**** **FIELD LETTER** ****

PROJECT #: 21-2867-A (Lot 170)

LOCATION: Lot 170, Duncans Creek

PLANS REF: The Cary – French Country Elevation Project #: 21-2867-LH (sealed 4-17-24)

S-2.1.1

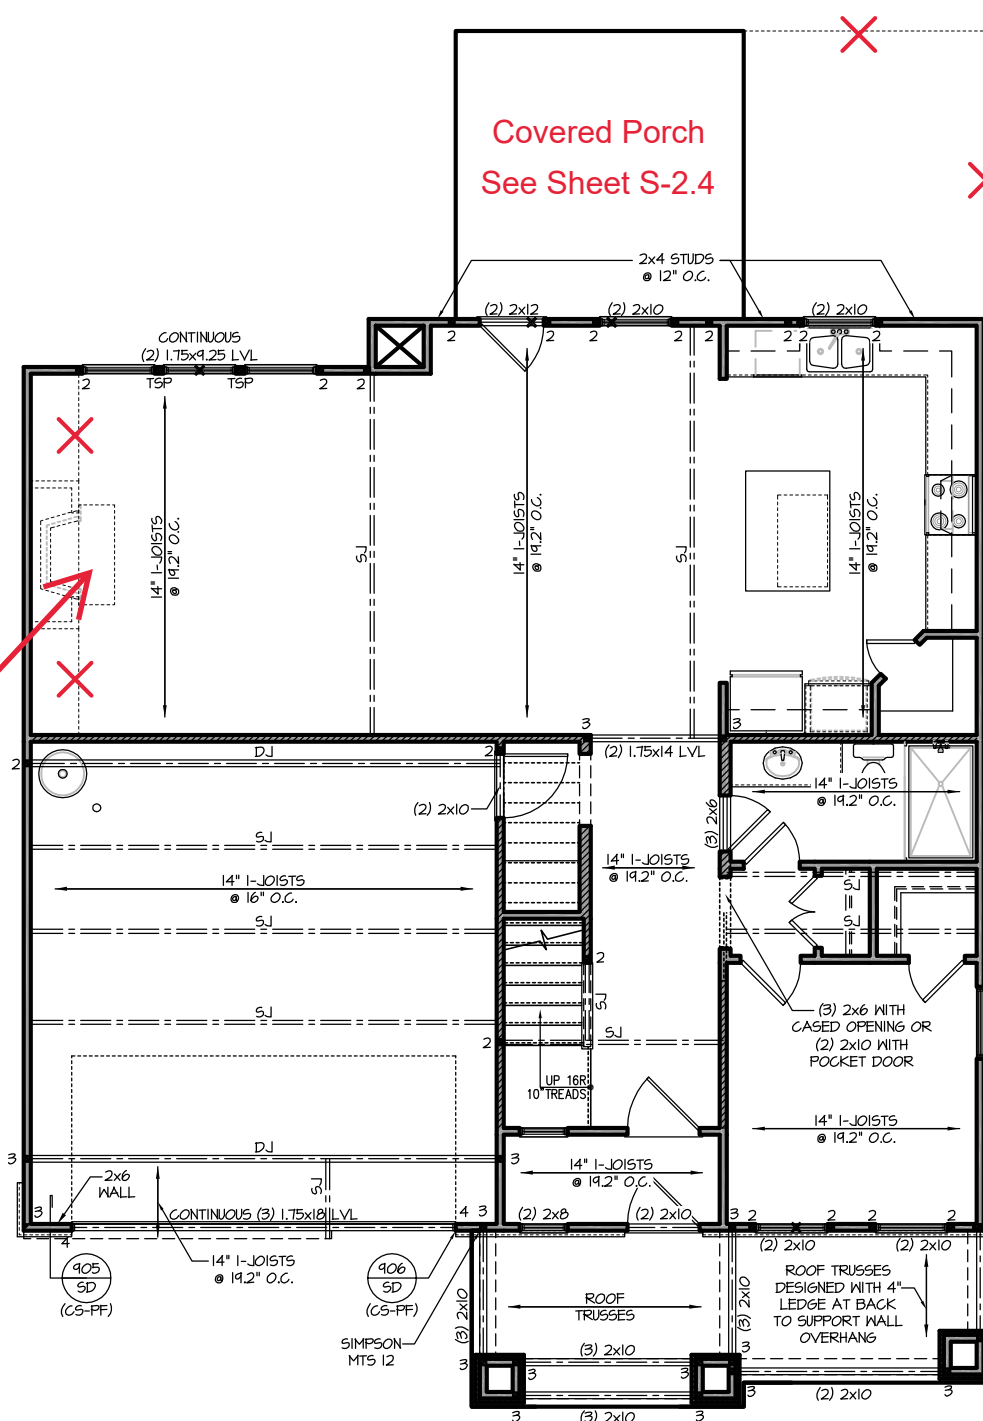
Notched Porch Header: Sheet S-2.1.1 of the plans shows a (3)2x10 header spanning front-to-back at the left side of the front porch. The back end of the header is shown to be supported at the garage wall by (3) studs. Based on information provided to Southern Engineers, the back end of the left ply of the (3)2x10 was notched at the garage wall due to the end of a floor truss encroaching into the same space. Approximately 3/4” of the left 2x10 ply was notched out of the beam above the wall to allow it to sit next to the floor truss. The right two plies of (2)2x10 are fully intact and have 3½” of bearing length on the wall.

Response: Please note that the above described notched porch header is structurally acceptable.
